EPC STORMWATER REVIEW COMMENTS
 IN ORANGE BOXES WITH BLACK TEXT

EL PASO COUNTY GRADING AND EROSION CONTROL PLAN CHECKLIST

DRAWING SCALE:
 HORIZONTAL: 1" = 60'
 VERTICAL: N/A

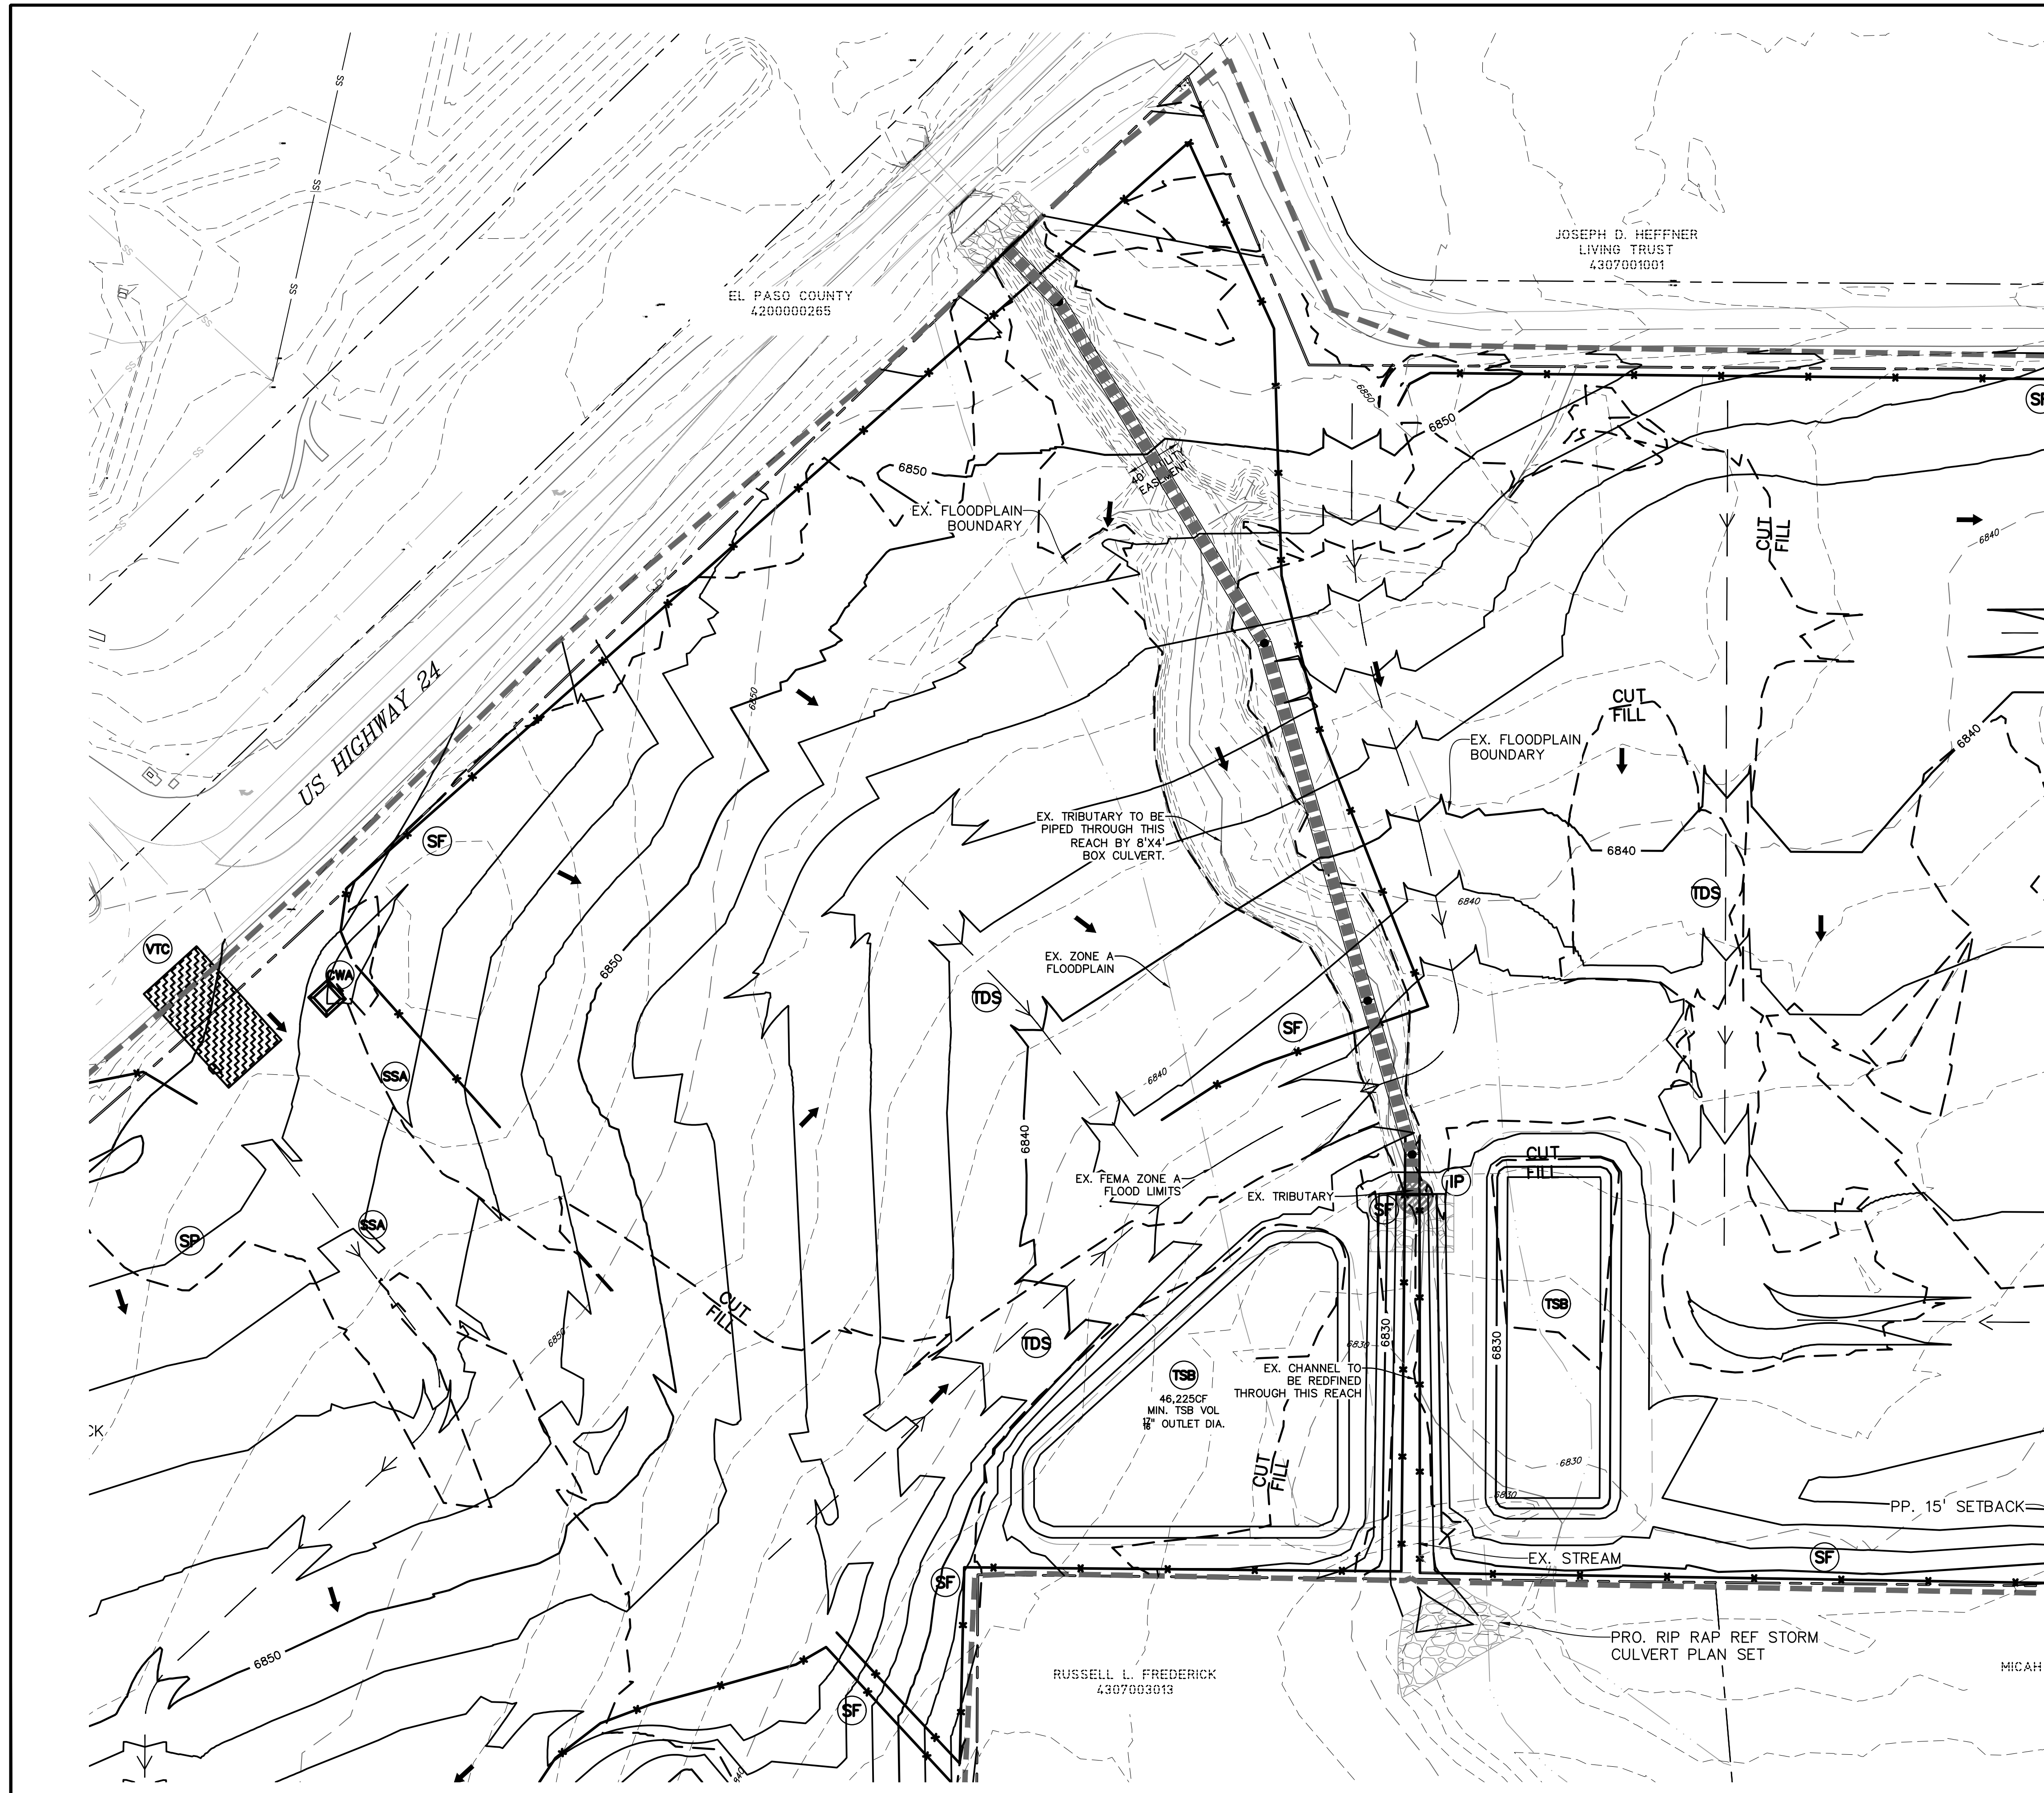
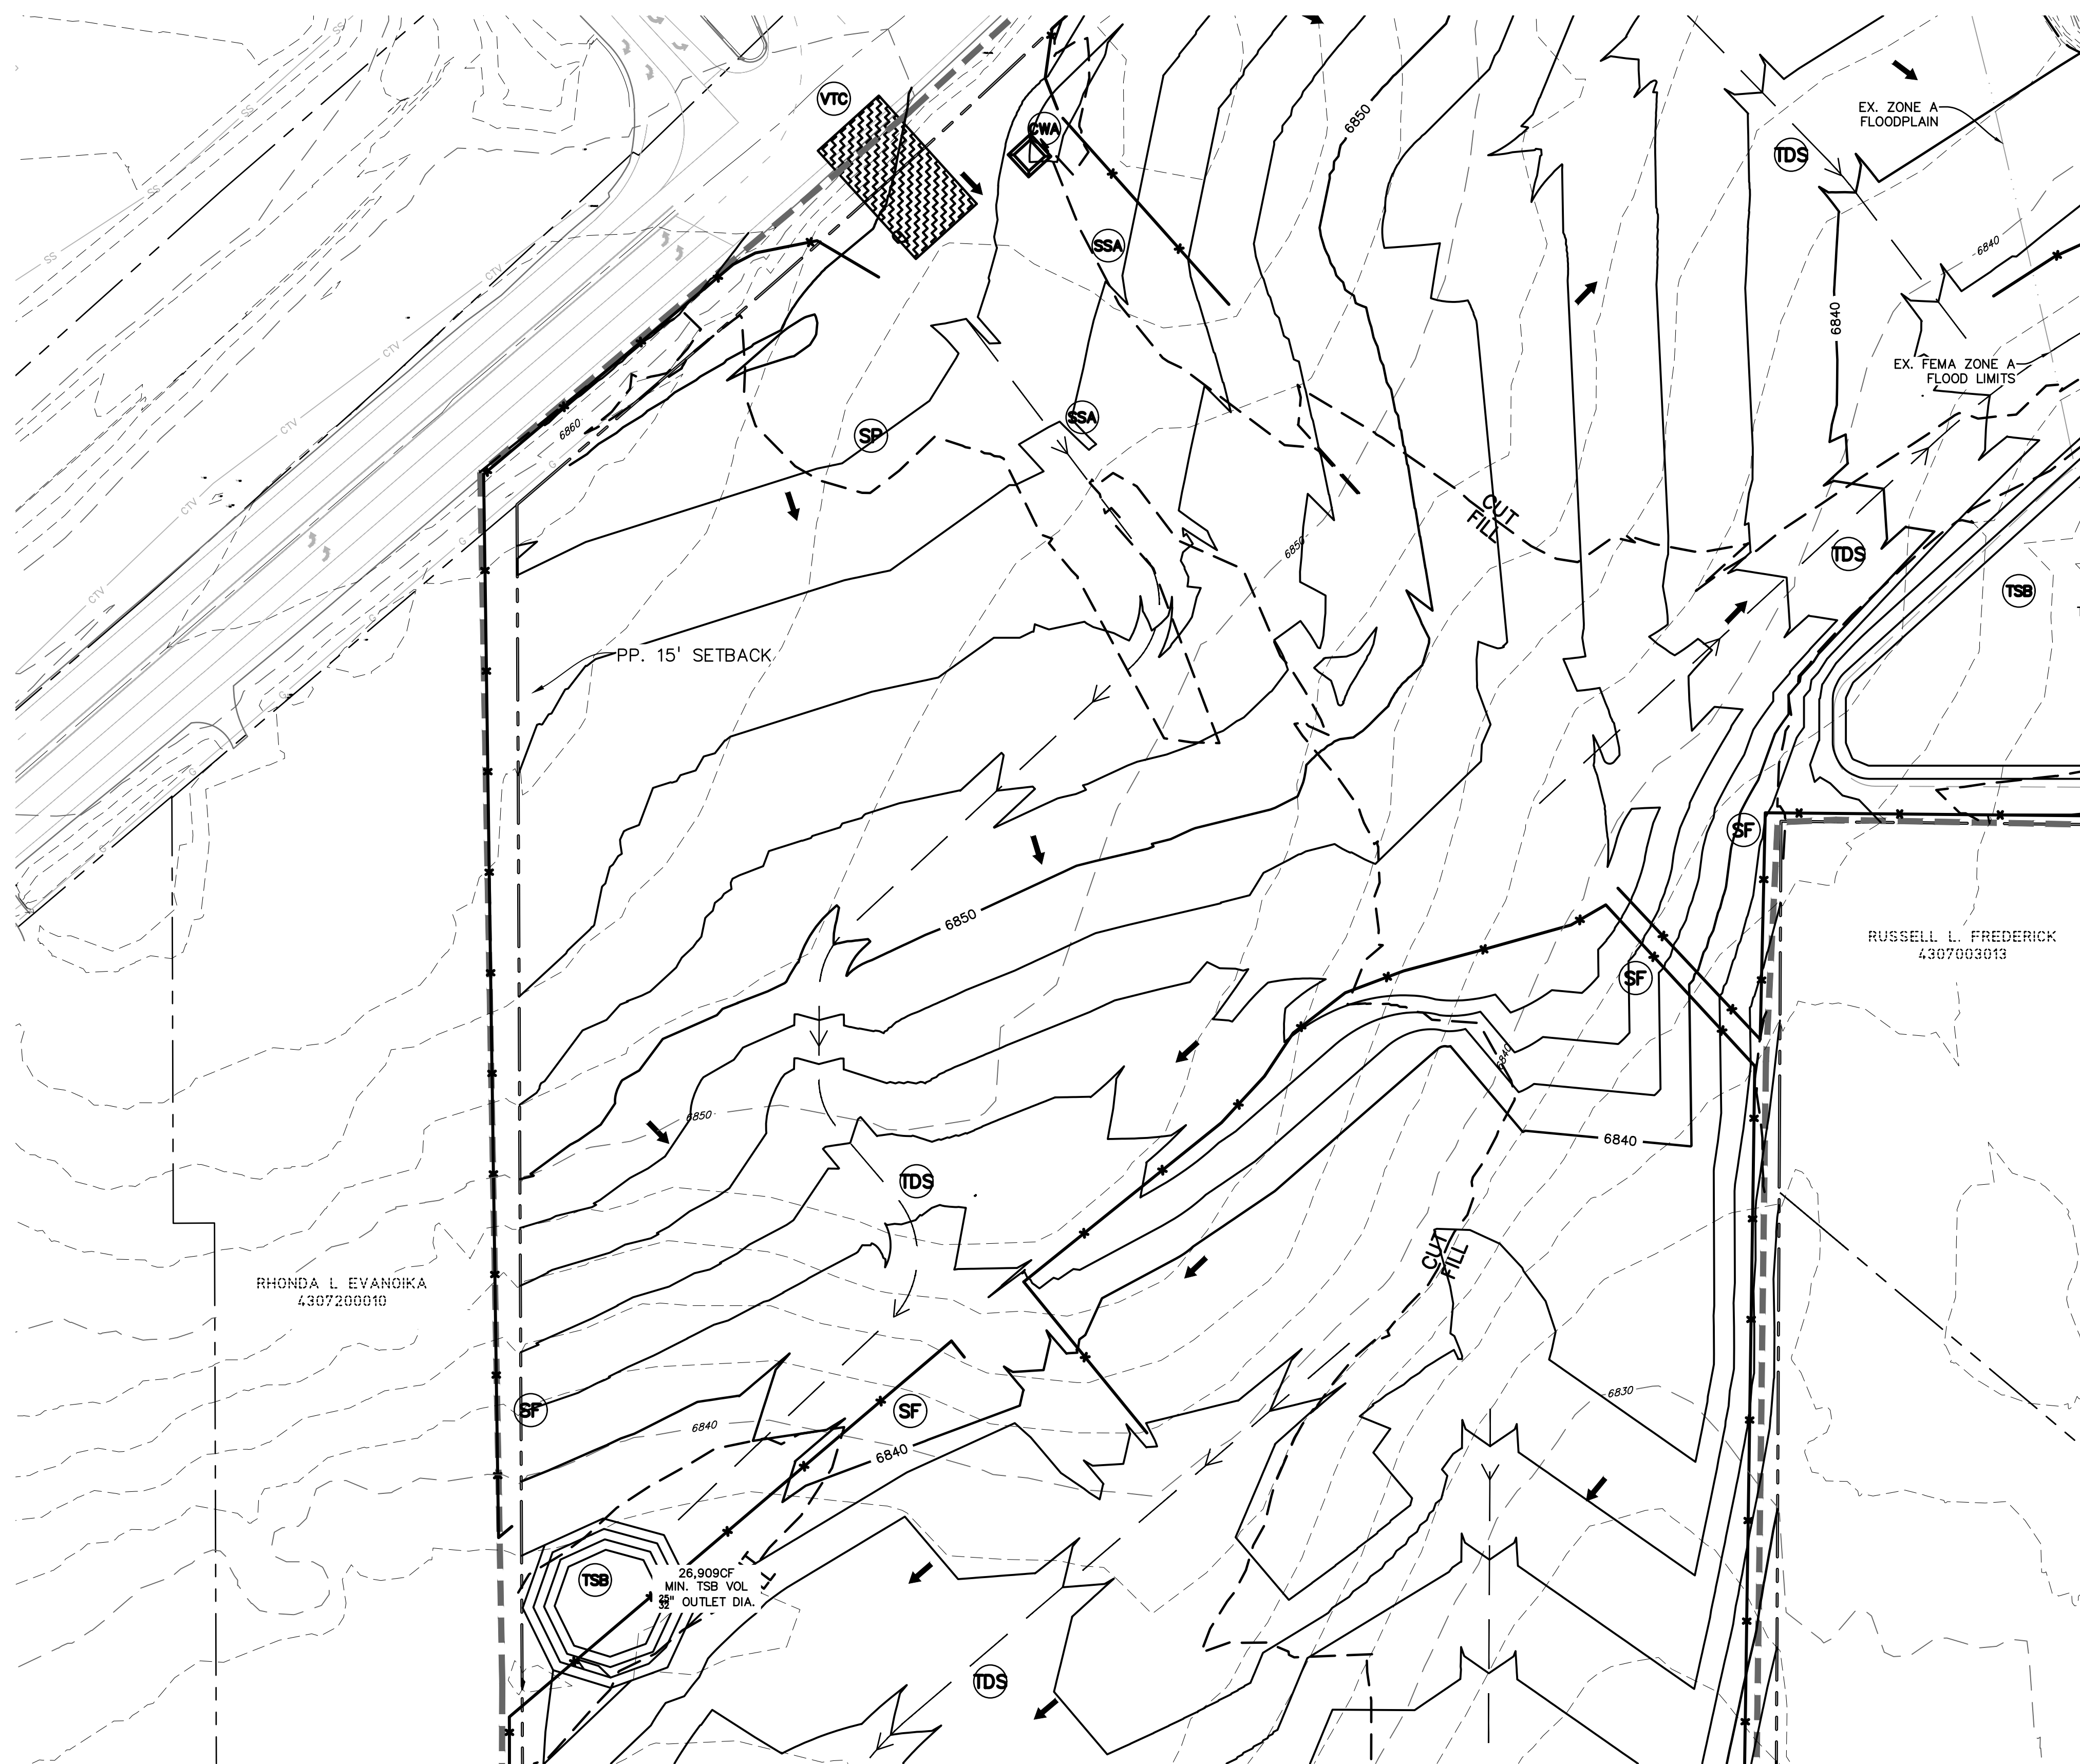
v	All proposed temporary construction control measures, structural and non-structural. Temporary construction control measures shall be identified by phase of implementation to include "initial," "interim," and "final" or shown on separate phased maps identifying each phase		N
w	Vehicle tracking provided at all construction entrances/exits. Construction fencing, barricades, and/or signage provided at access points not to be used for construction		Y
x	Temporary sediment ponds provided for disturbed drainage areas greater than 1 acre		Y
